Subject: Yew Tree House
Importance: High

16/00247/DISC of 16/00080/F

16/00250/DISC of 16/00081/LB

Ground Floor Plan
 1 : 50
 VISUAL SCALE 1:50 @ A1

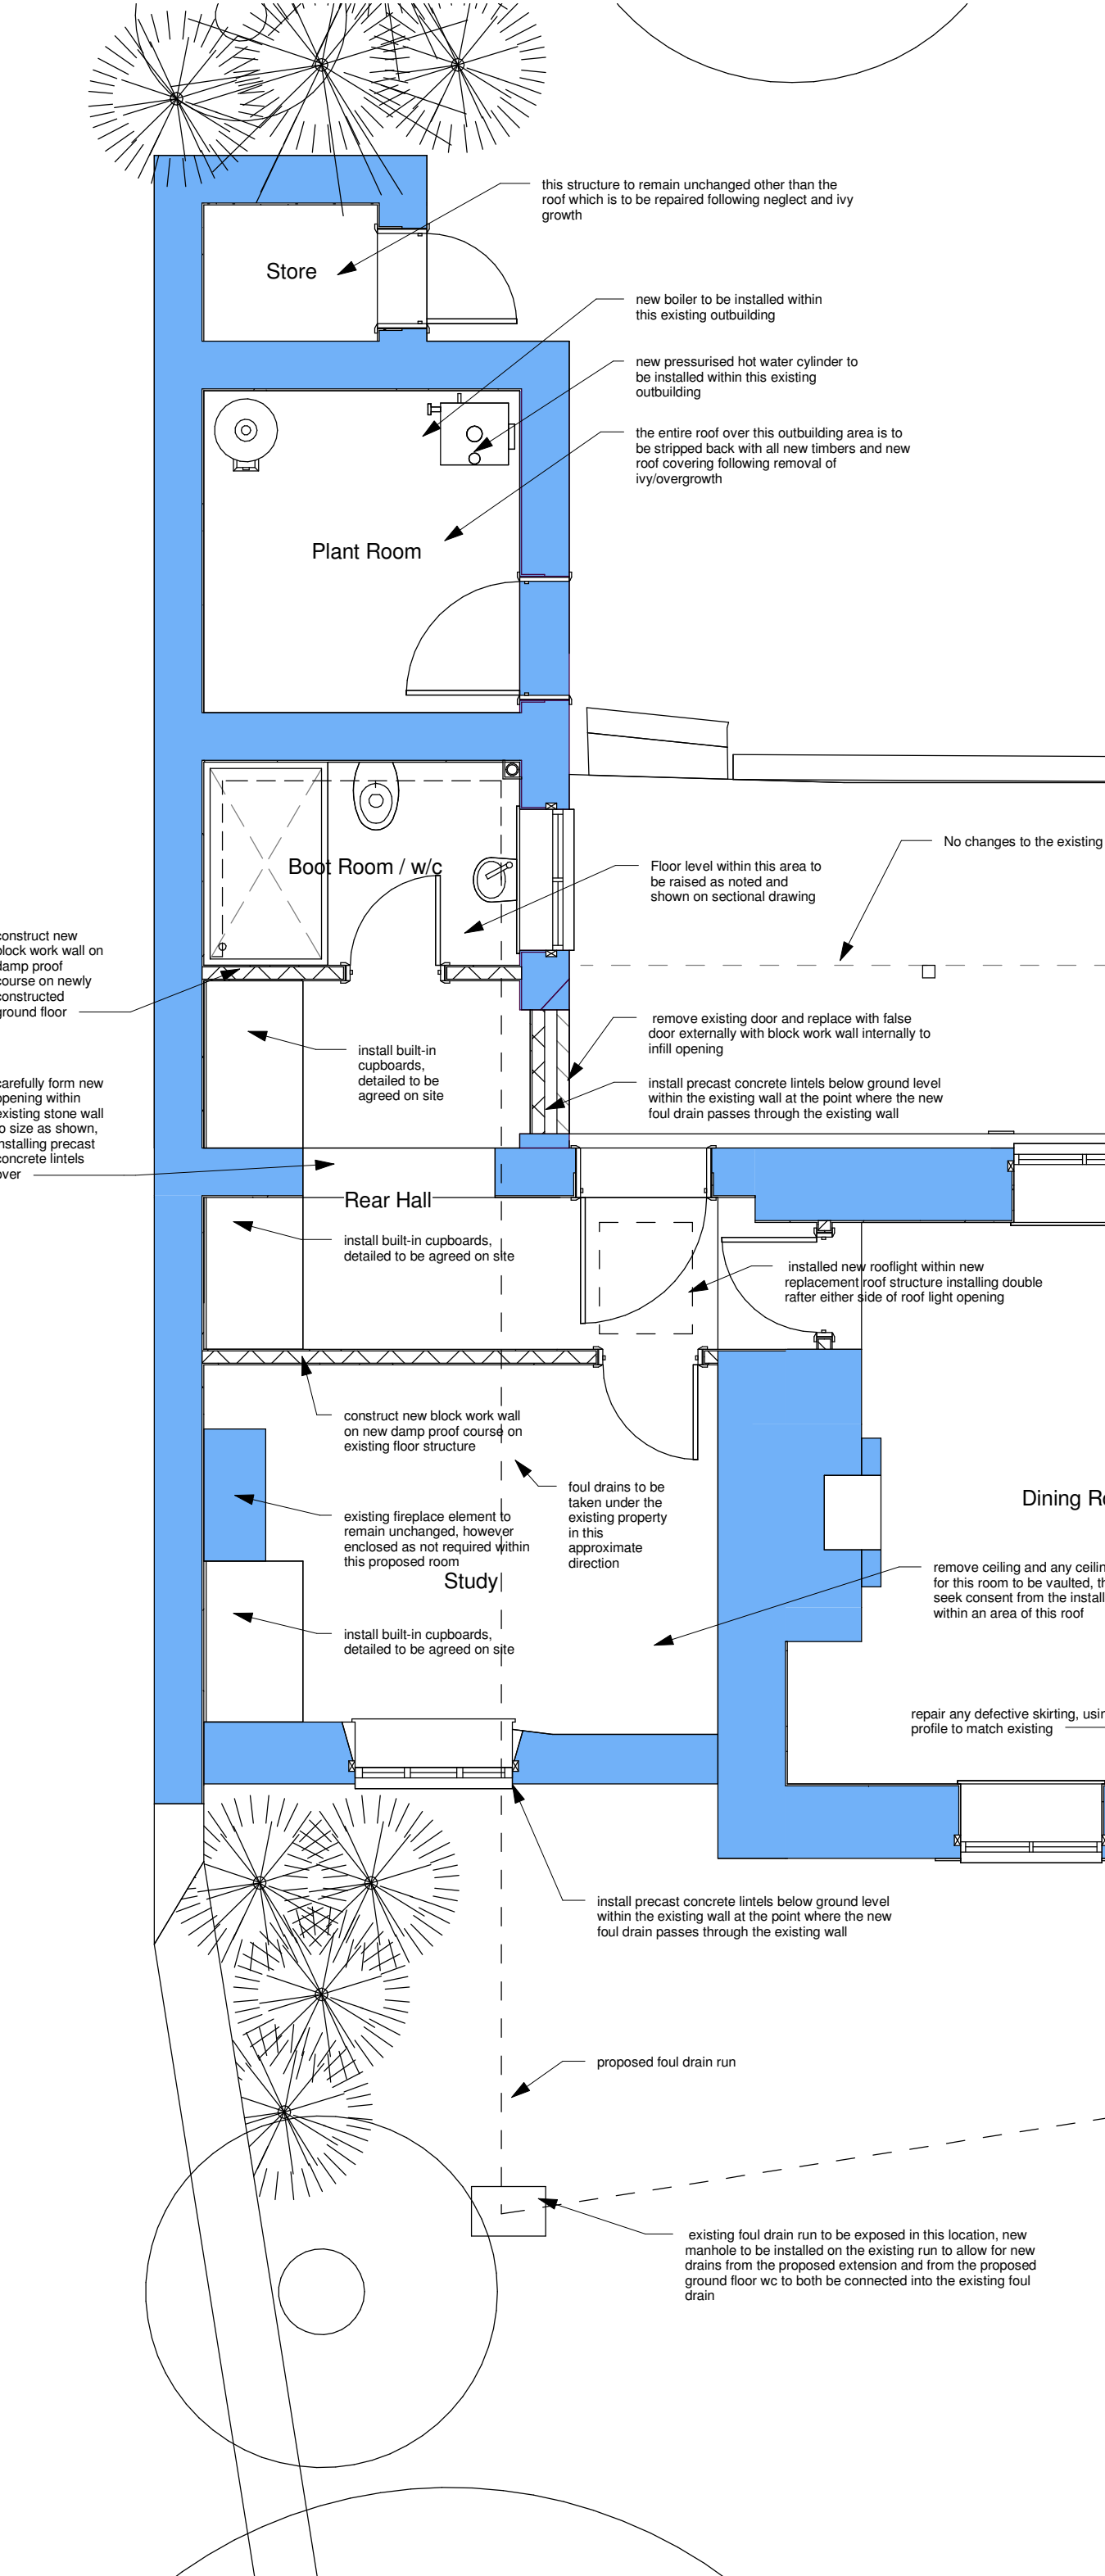
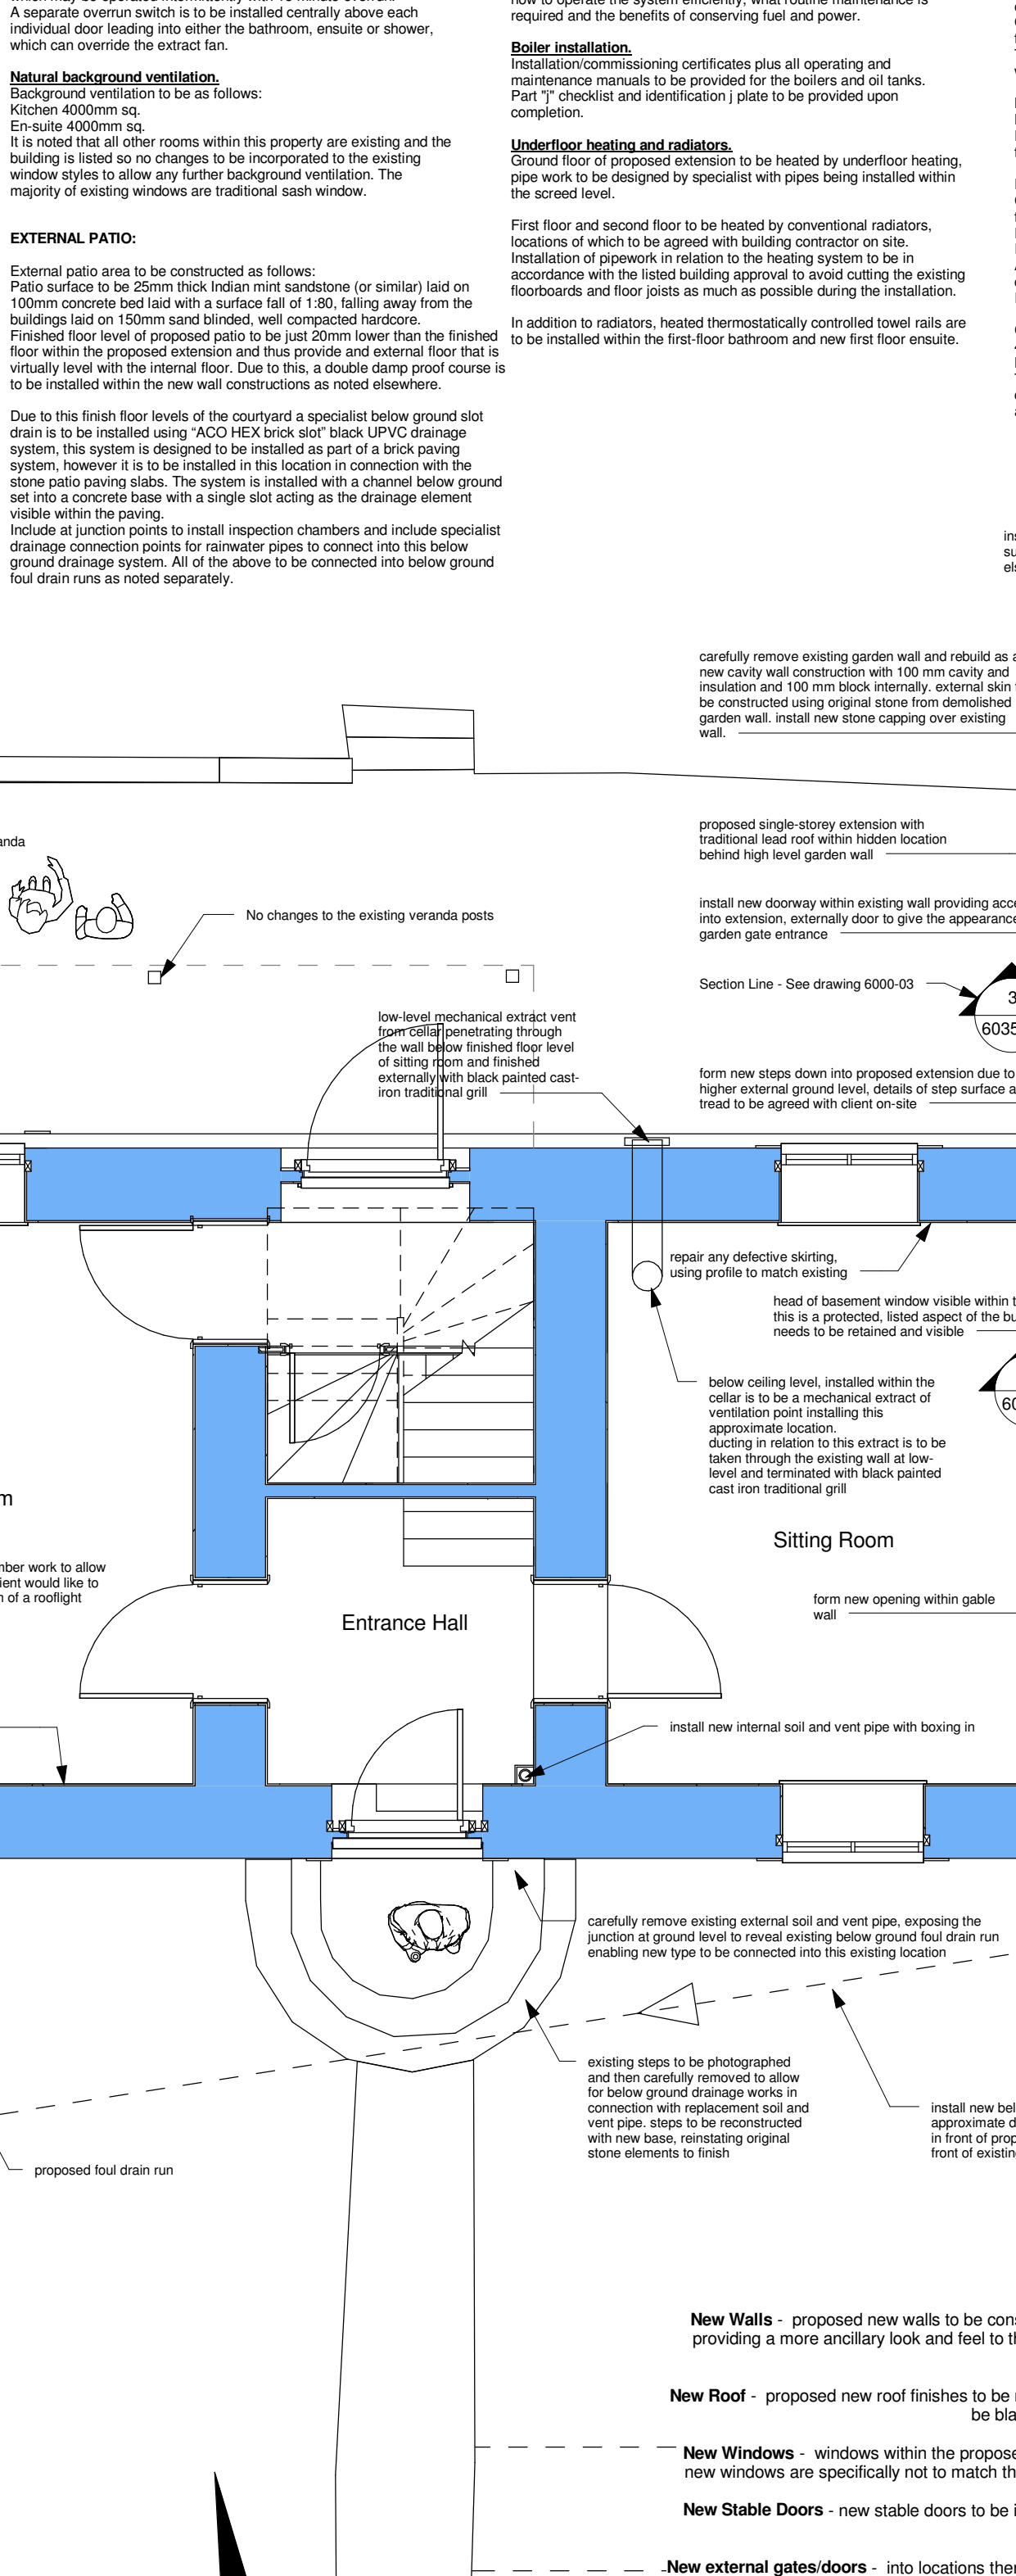
The preapp recommended breathable walls, floors and roofs in historic buildings. Query – has a radon test been carried out to establish if a Radon barrier is required

Query note which states floor levels are to match that of the existing house with solid floor proposed – How will a concrete floor affect the existing walls?

Query if the designer has provided a risk assessment as to how the proposed new concrete floor with its dpm will impact on the cellar conditions – what happens where the dpm abuts the historic wall? The notes mentions a radon sump, where is this?

We have no details of how the mechanical ventilation is being dealt with to the bathrooms, bootroom in terms of impact on the historic fabric – please provide further detail. NB re natural background ventilation note - trickle vents in windows are not acceptable on a listed building please provide alternative detail – please provide details of how you propose to achieve background ventilation – will this be via restrictors on the sash windows etc?

French Door Elevation

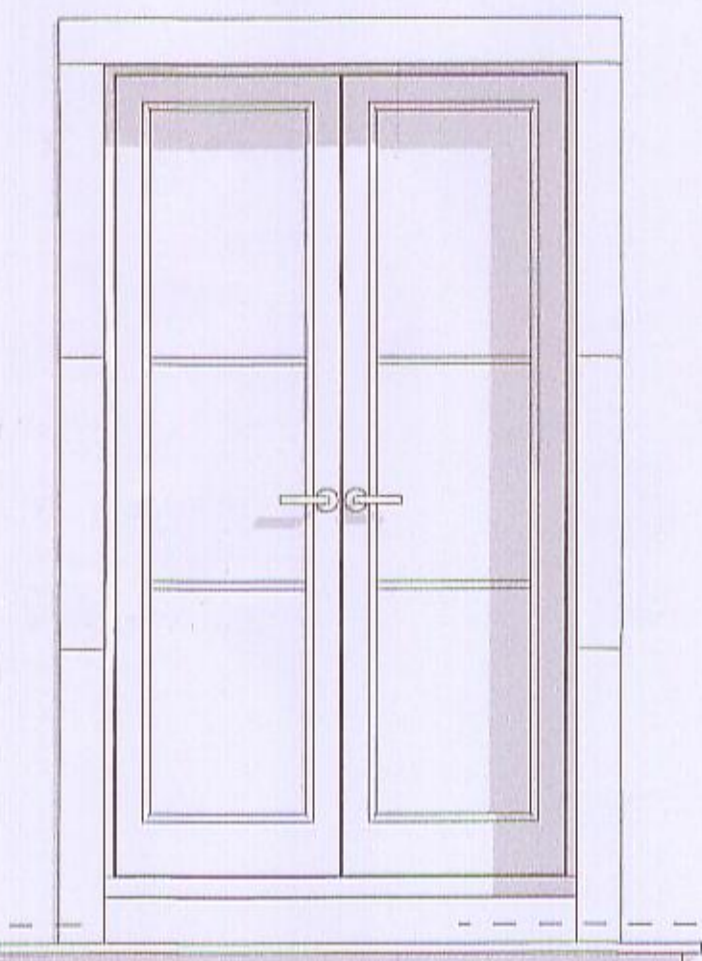
3 (french doors) - principle has already been agreed need joinery details.

Revised Bootroom

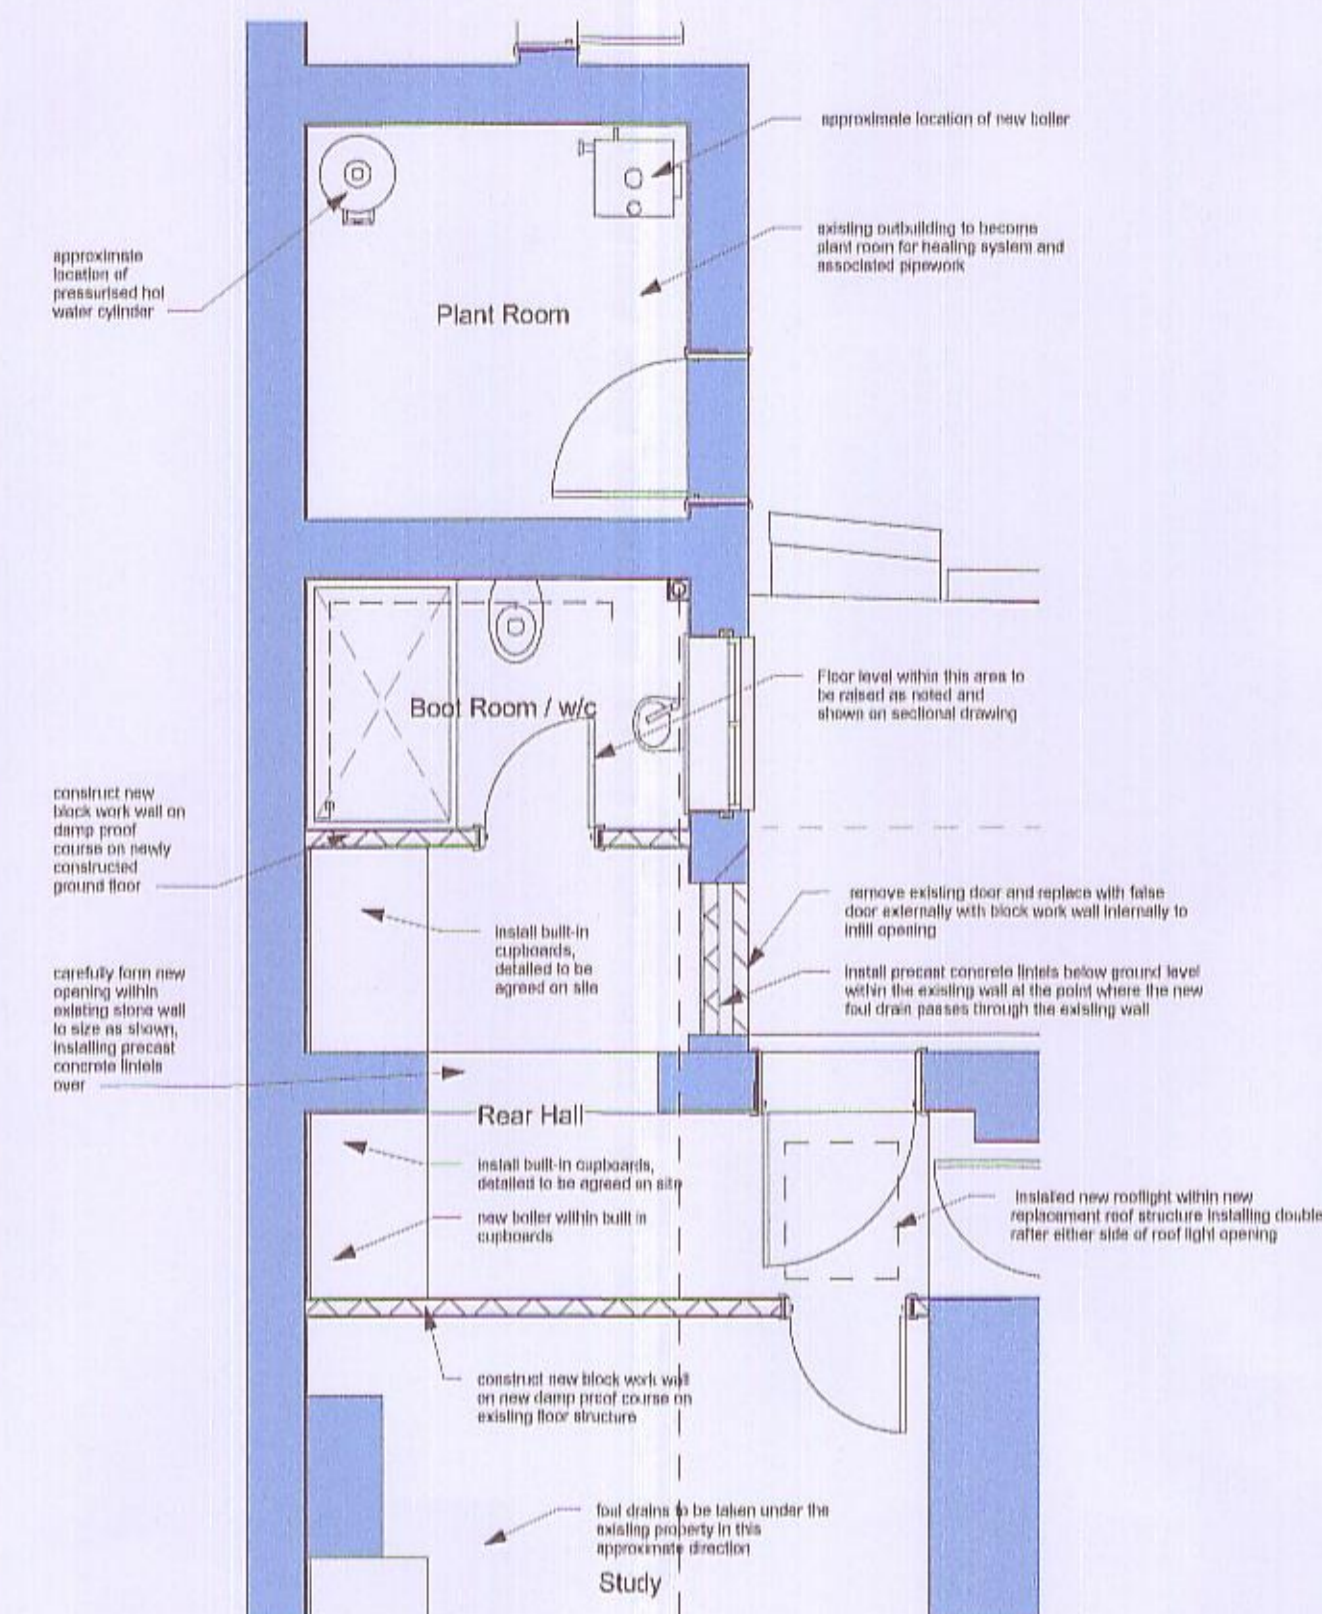
Care needs to be taken to vent the rear of the door to match the existing door if the original is not being reused. Does the whb fit under the window whilst allowing a splashback?
